Consultation Response from KC Highways Development Management		
2026/92191 Land to the south of Common Lane, Denby Dale, Huddersfield, HD8 8YN		
Conversion and extension of existing barn to form single dwelling		
Date Responded: 15/10/26	Responding Officer: M Zenner	Responding Ref: 17-10/43
RECOMMENDATION: There are no objections in principle to the proposals, however some amendments and further information should be provided. Further information/amendments are required in relation to: ➤ HDM requires the gate to be set back a minimum of 5m from the edge of the adopted highway; ➤ Cycle parking is required; ➤ The waste management store or a bin collection point in close proximity to the public highway should be demonstrated (this must not impede existing sight lines onto Common Lane); ➤ Parking for four vehicles should be demonstrated within the site and HDM would recommend that the turning space is enlarged to ensure vehicles egress the site in forward gear. Development Overview: The submitted application is described as the conversion and extension of an existing barn to form a single dwelling. HDM notes the proposed dwelling has four bedrooms and the main pedestrian entrance to th

Drawing Title.  
**PLANS & ELEVATIONS  
AS PROPOSED**

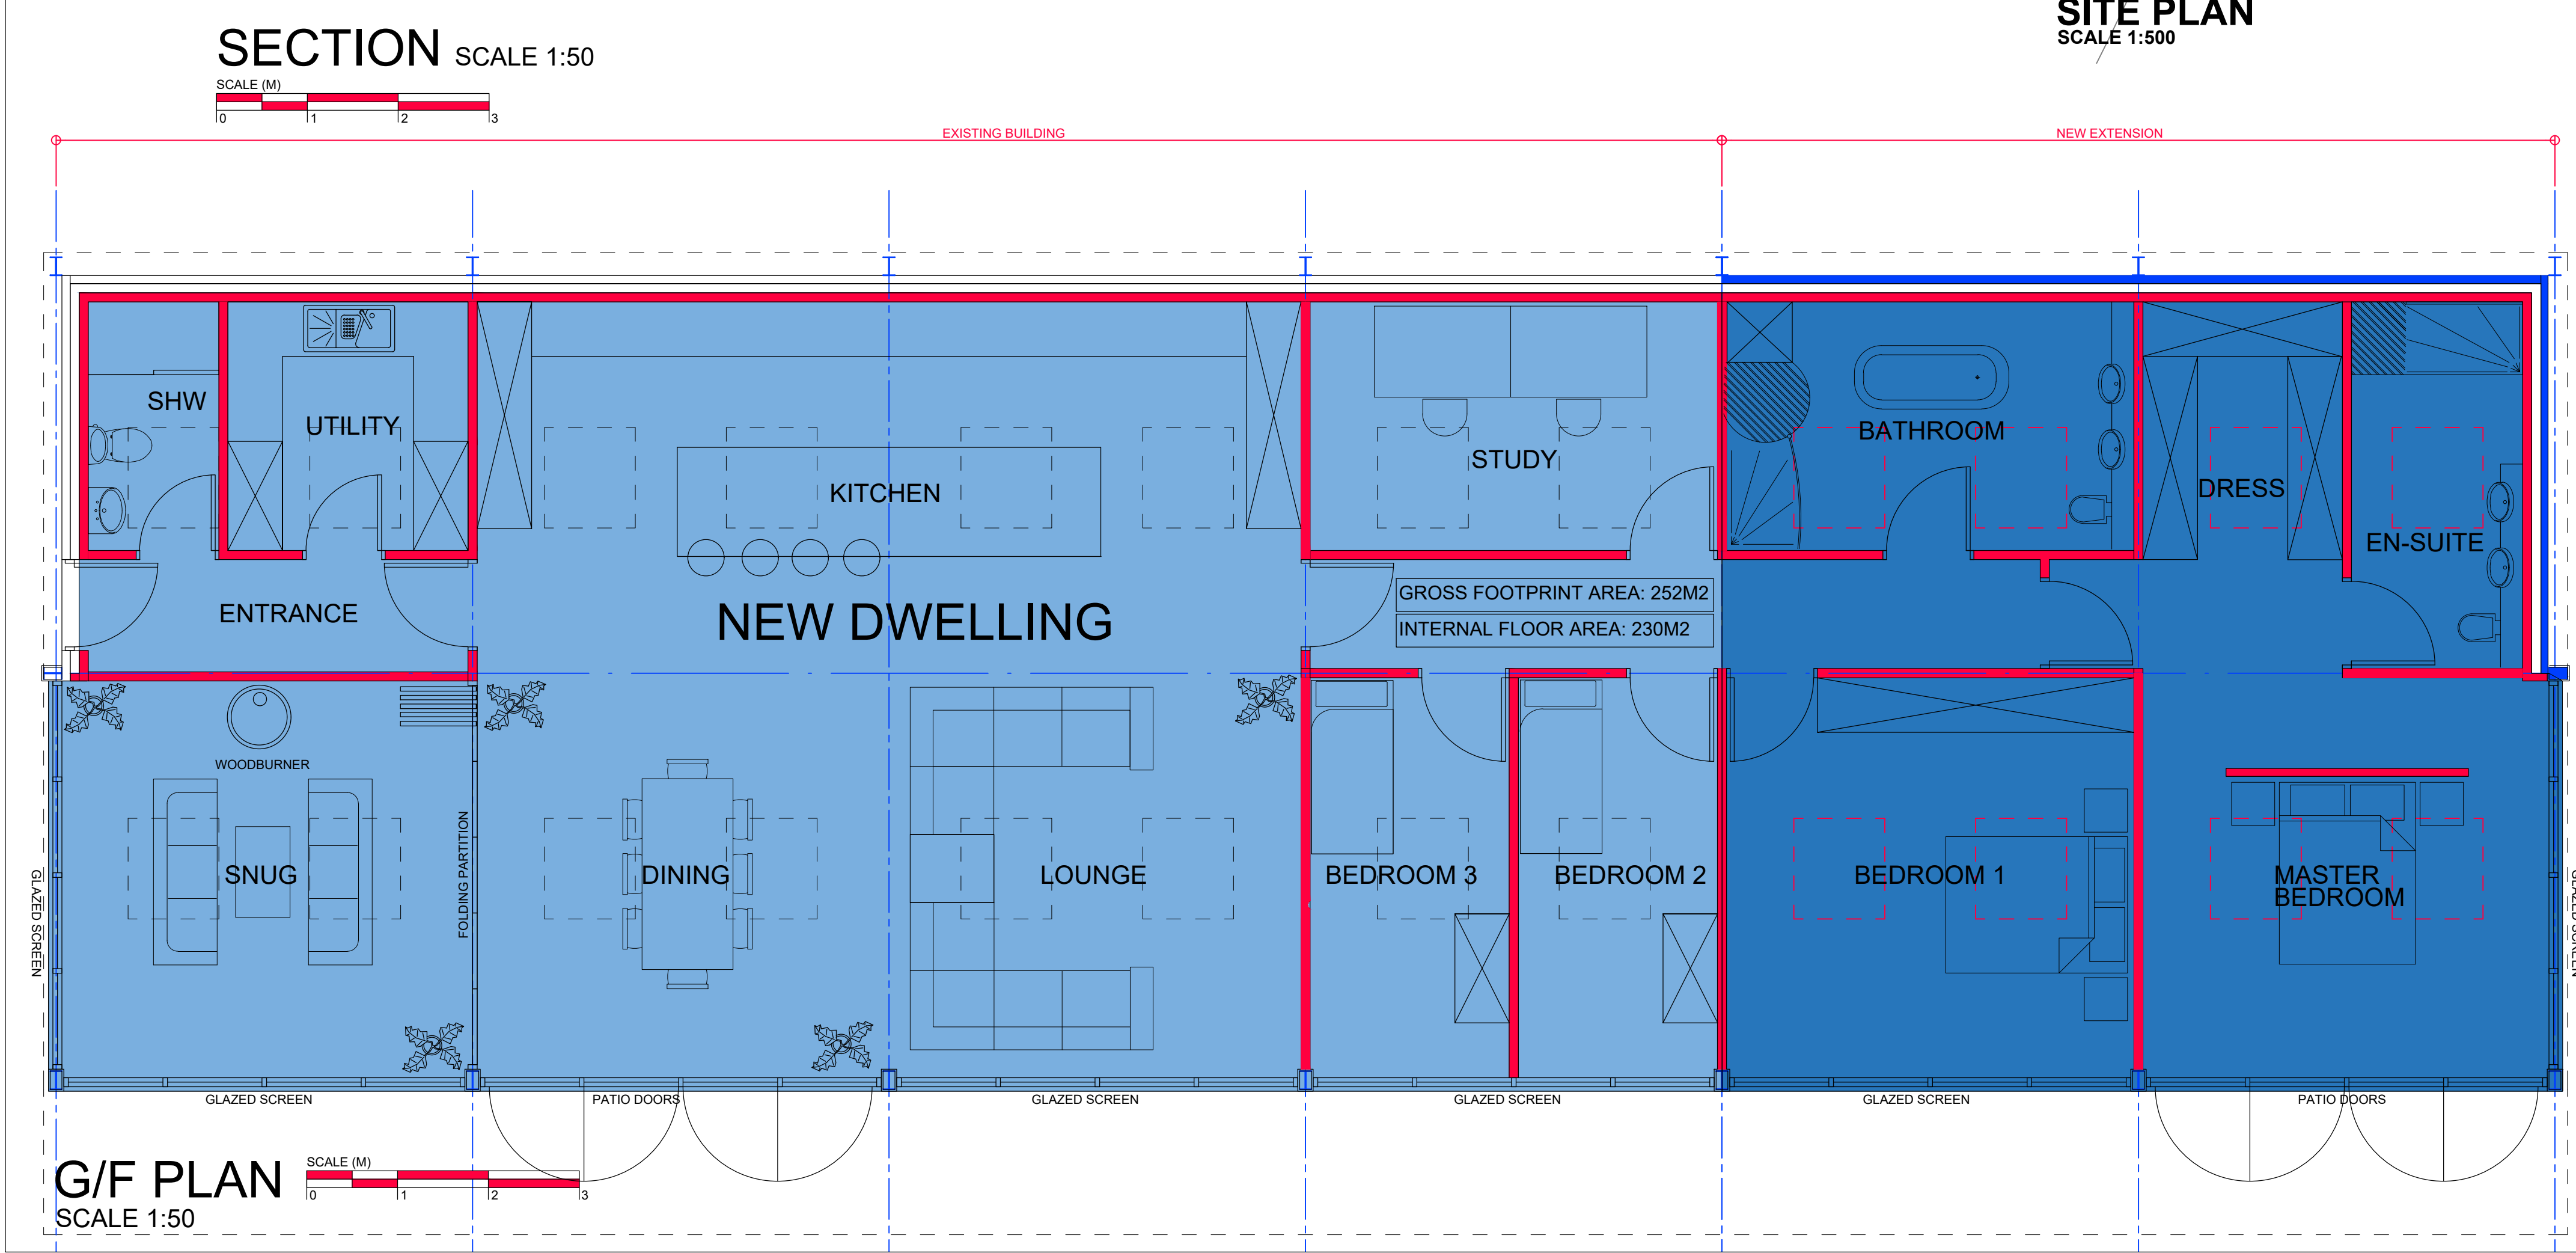
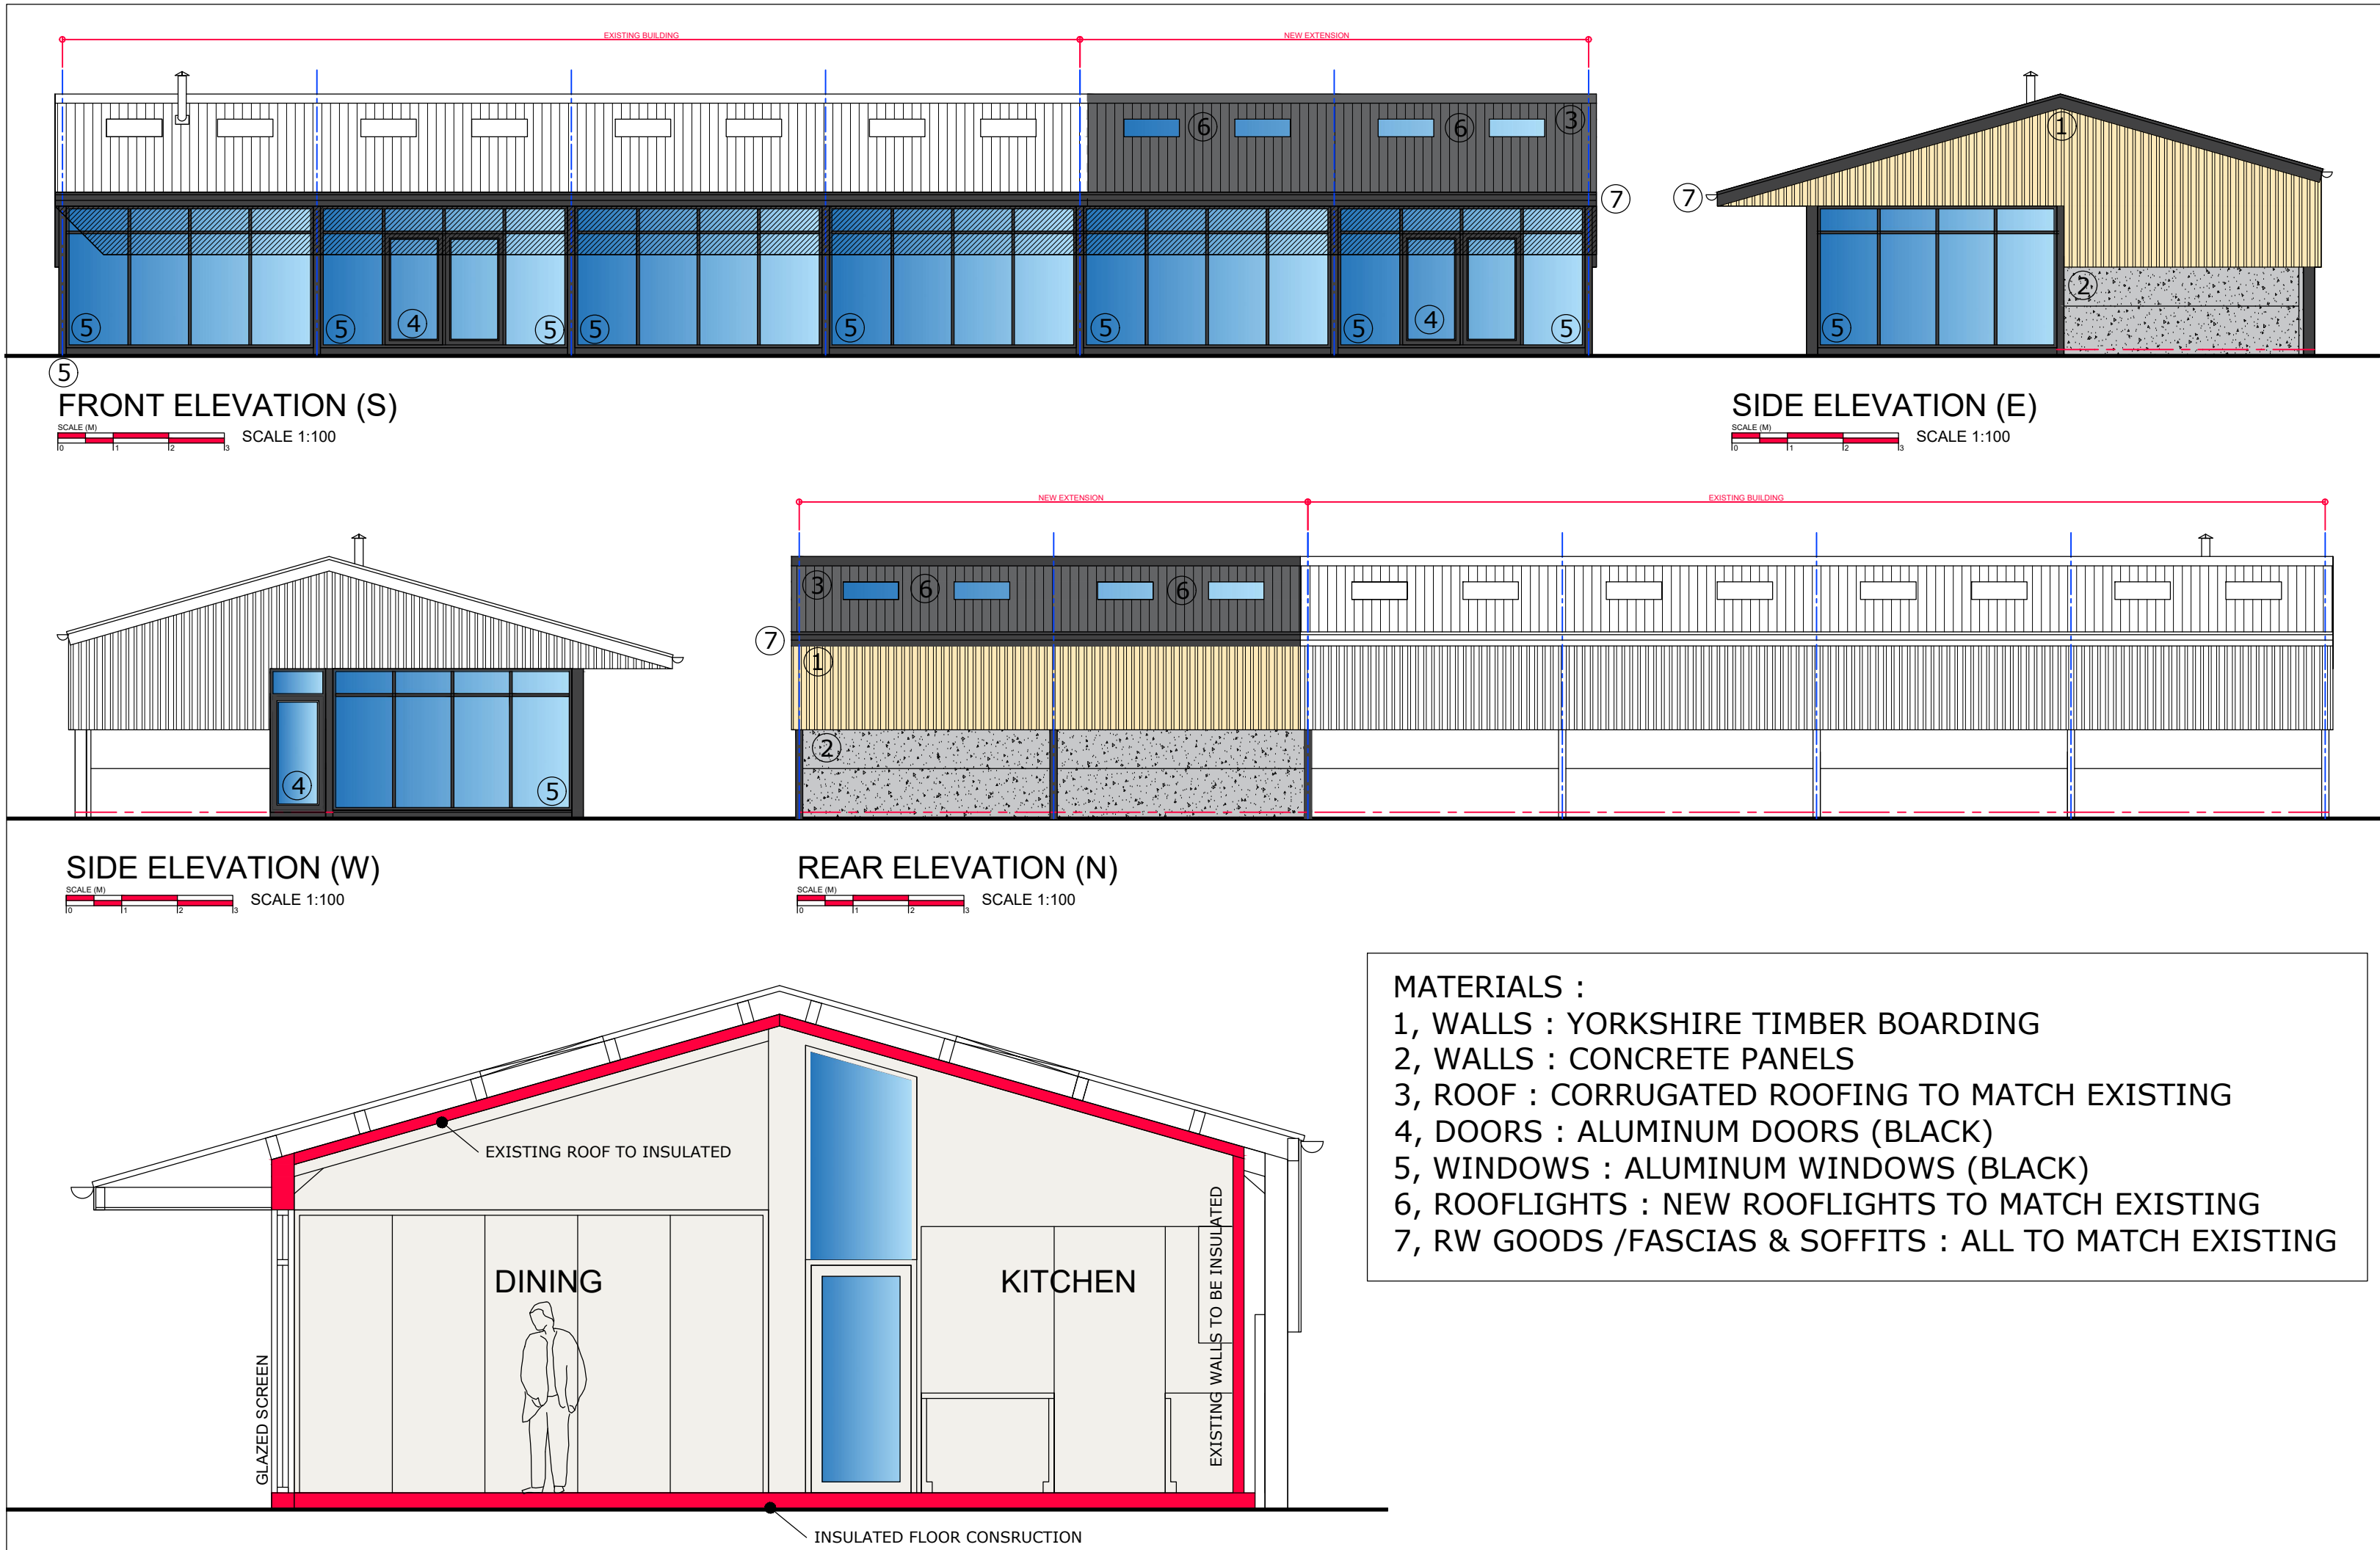
The proposed site access is the existing gated access to the site which is approximately 5.5m wide. The existing gates are set back less than 3m from the adopted highway and would result in cars overhanging the carriageway whilst opening the gate which could cause obstruction and compromise highway safety at the site access. Therefore, HDM requests that the gates must be set back a minimum of 5m from the public highway to ensure that no blocking back of the public highway results from the proposals.

HDM notes that there is gravel proposed on the driveway; gravel can reduce road surface resistance to skidding. HDM notes that the proposals also include block paving for the first 6.7m depth of the site entrance and considers this is an adequate distance to ensure gravel does not spill over onto the public highway.

On this basis the proposed dwelling should be provided with four car parking spaces, three for the residents and one visitor parking space. Two cars are shown on the submitted proposed site layout plan, one either side of the pedestrian door to the dwelling. Whilst it is considered that the site can accommodate four parked cars, the layout is quite tight and would benefit from an enlarged area to enable vehicles to turn and exit in forward gear.

Whilst the Highway Design Guide recommends one cycle space per unit, HDM encourages the provision of one cycle parking space per bedroom to comply with the standards set out in LTN 1/20. Cycle parking should be provided at ground floor level in an accessible location. No cycle parking appears to be outlined within the submission which needs to be provided.

HDM would recommend the applicant review the Kirklees Waste Management Design Guide For New Developments (Oct 2020) which sets out the refuse requirements per dwelling and for bin collection points. A bin collection point should be provided in close proximity to the adopted highway and must not impede existing sight lines from the site access.
